Subject: Rezoning Petition Review

Date of Review: January 27, 2022 (*Revised February 25, 2022*)

Rezoning Petition #: 21-216

Location of Property: Approximately 41.26 acres located on the west side of Old Holland Rd, east of I-85 and north of Morehead Rd.

OVERALL SITE
PLAN

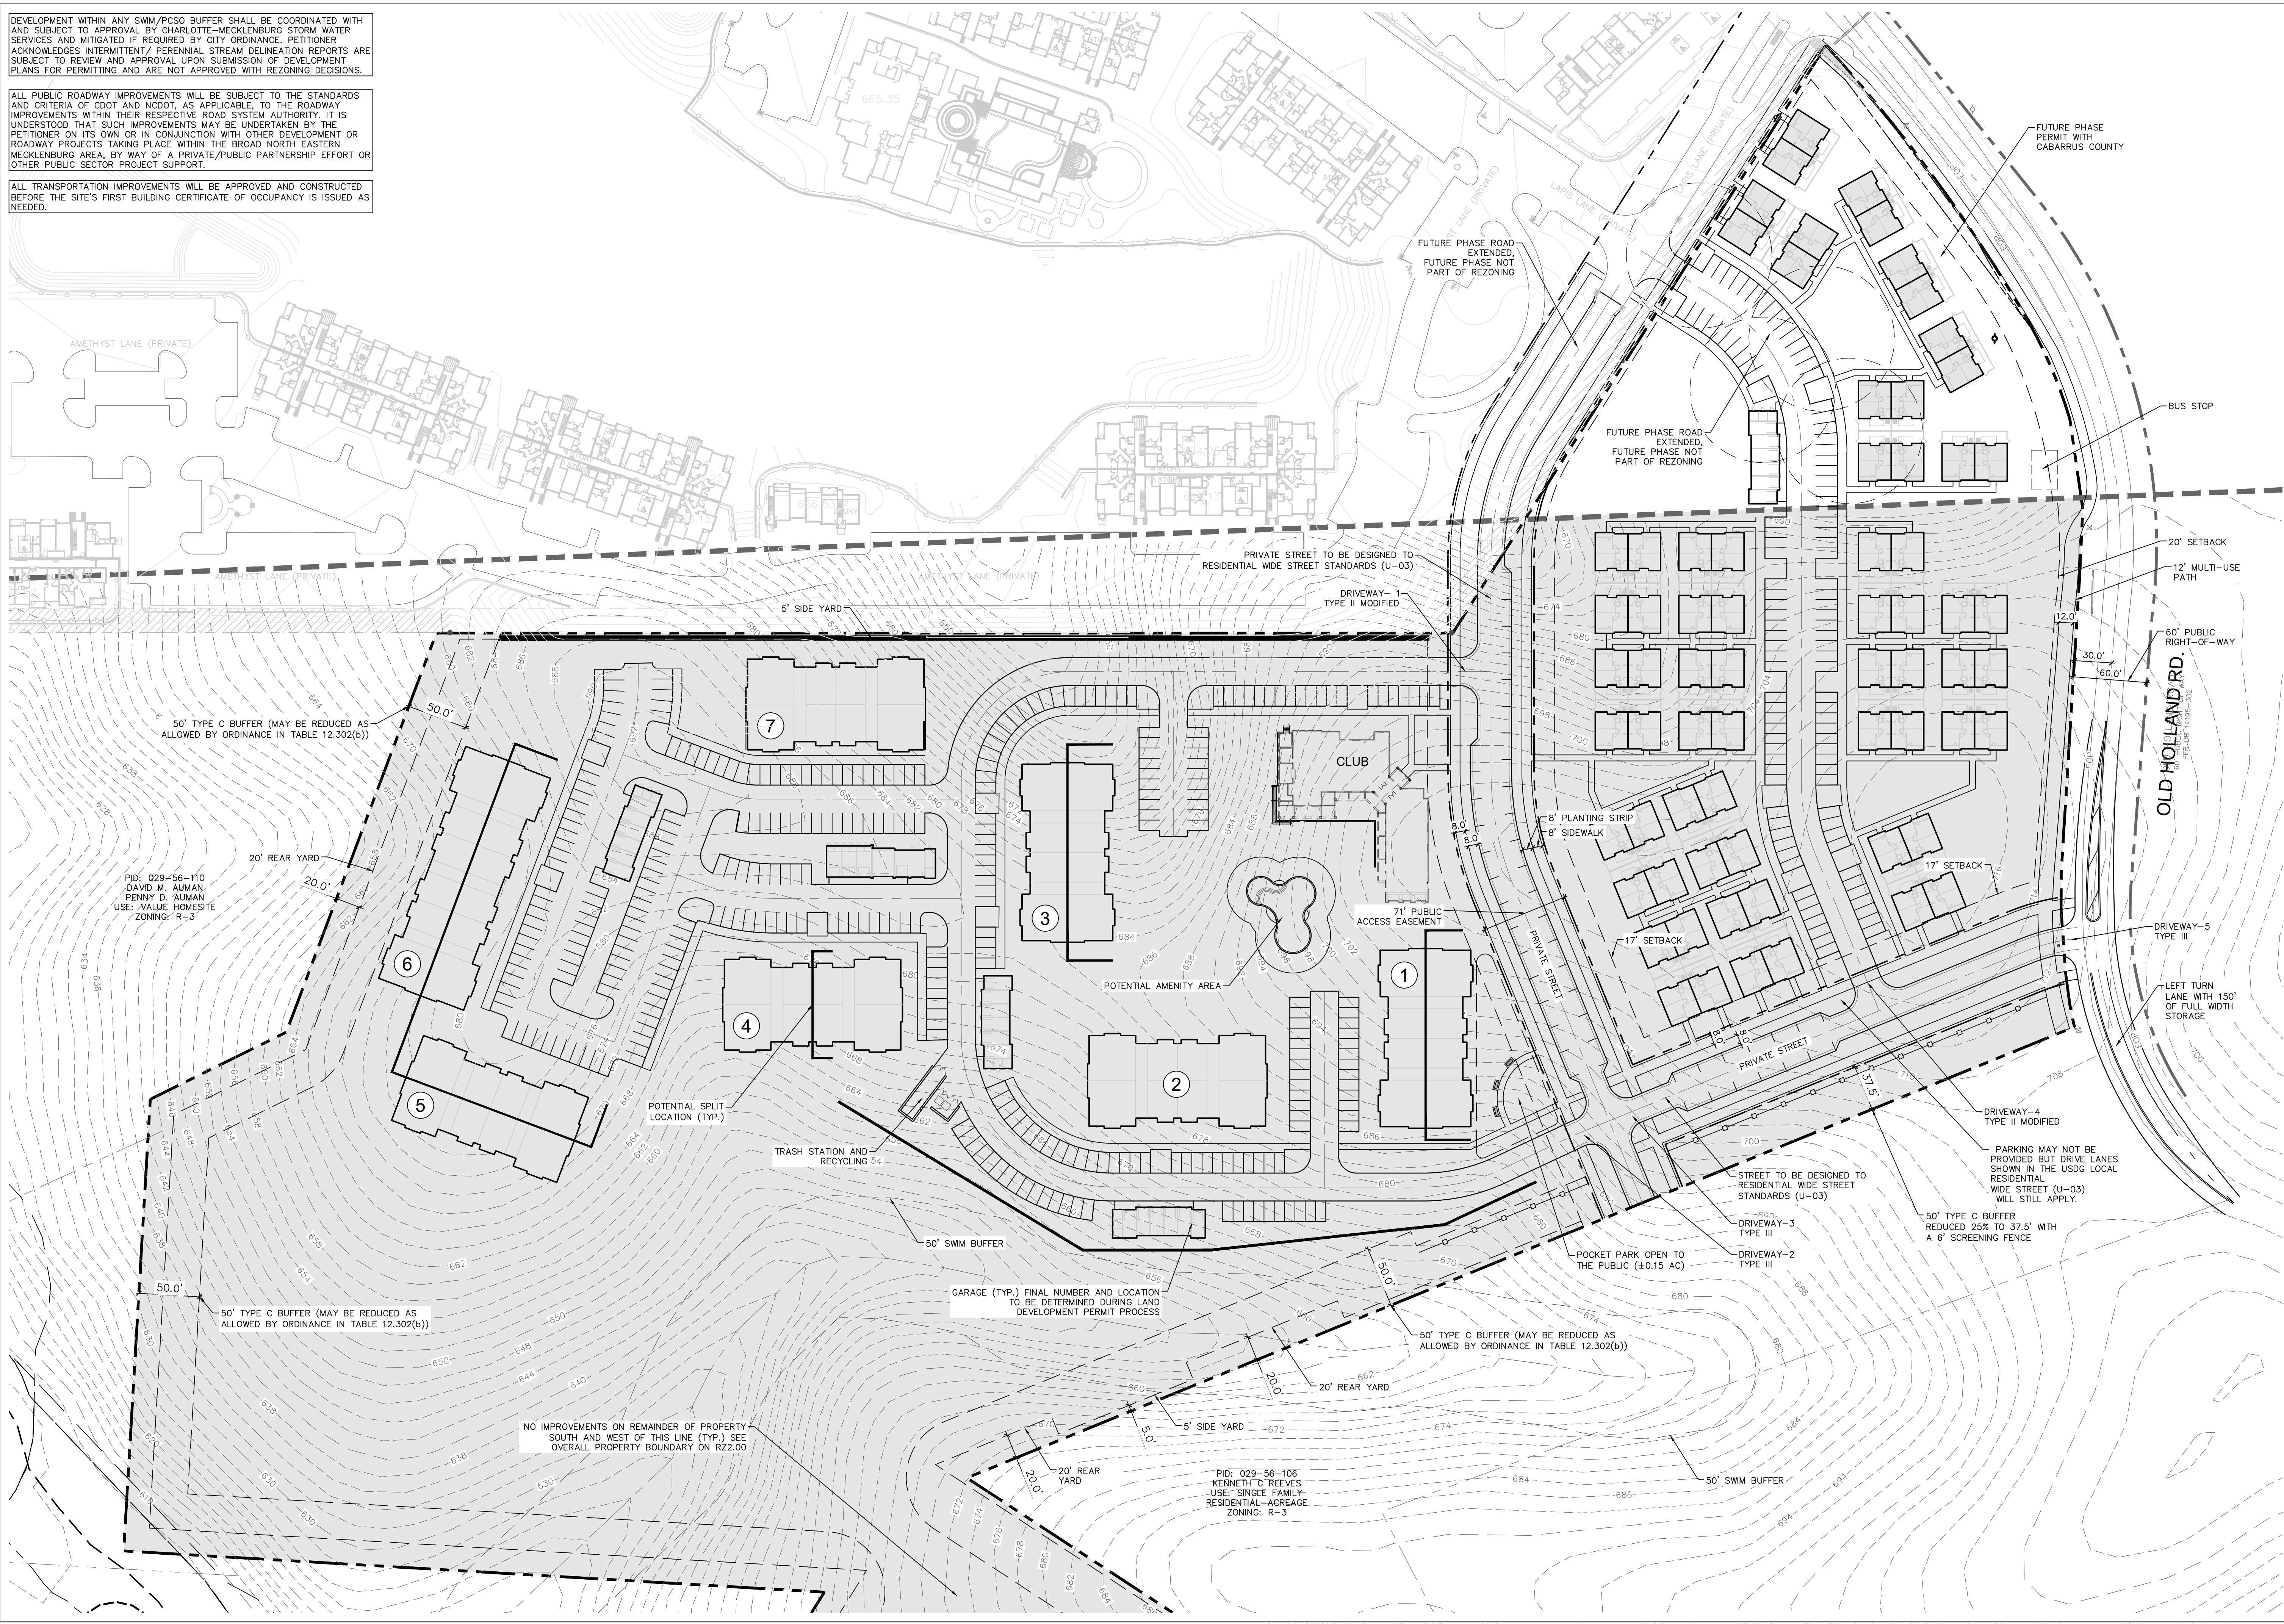
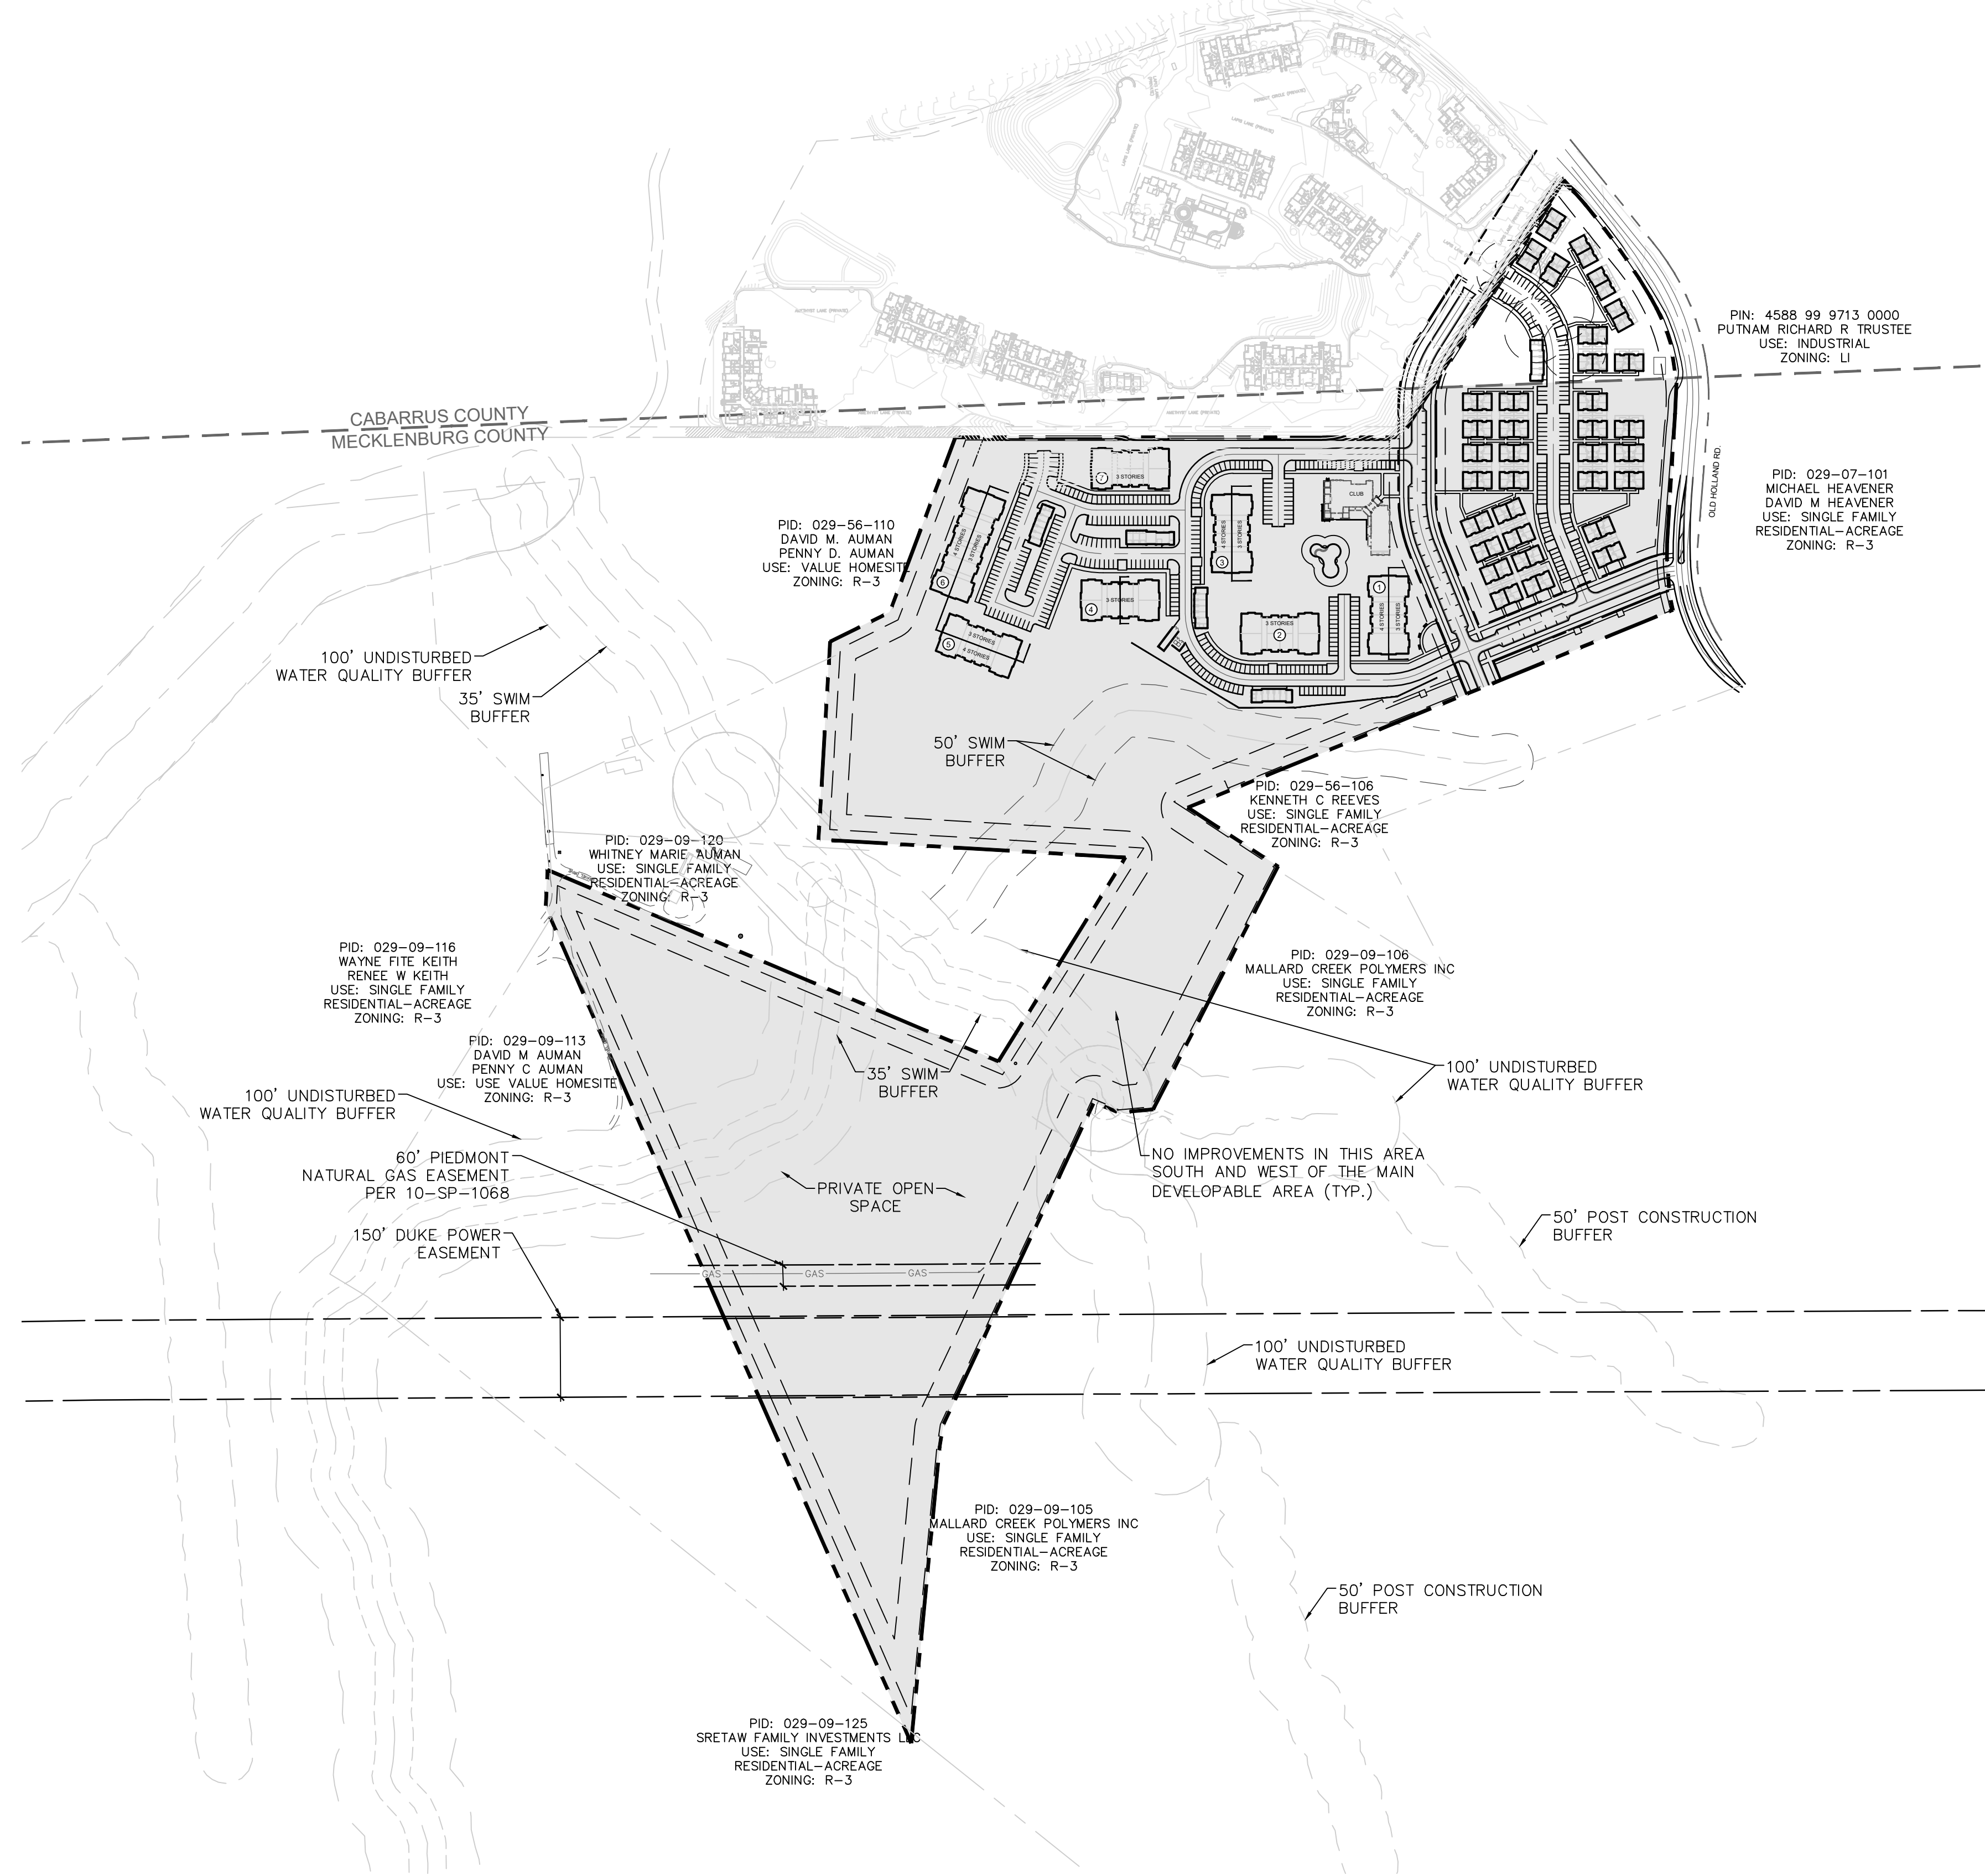
Please label (size and type) of all SWIM/PCSO buffers on site and include the following note on the site plans:

- Development within any SWIM/PCSO Buffer shall be coordinated with and subject to approval by Charlotte-Mecklenburg Storm Water Services and mitigated if required by City ordinance. Petitioner acknowledges intermittent/perennial stream delineation reports are subject to review and approval upon submission of development plans for permitting and are not approved with rezoning decisions.
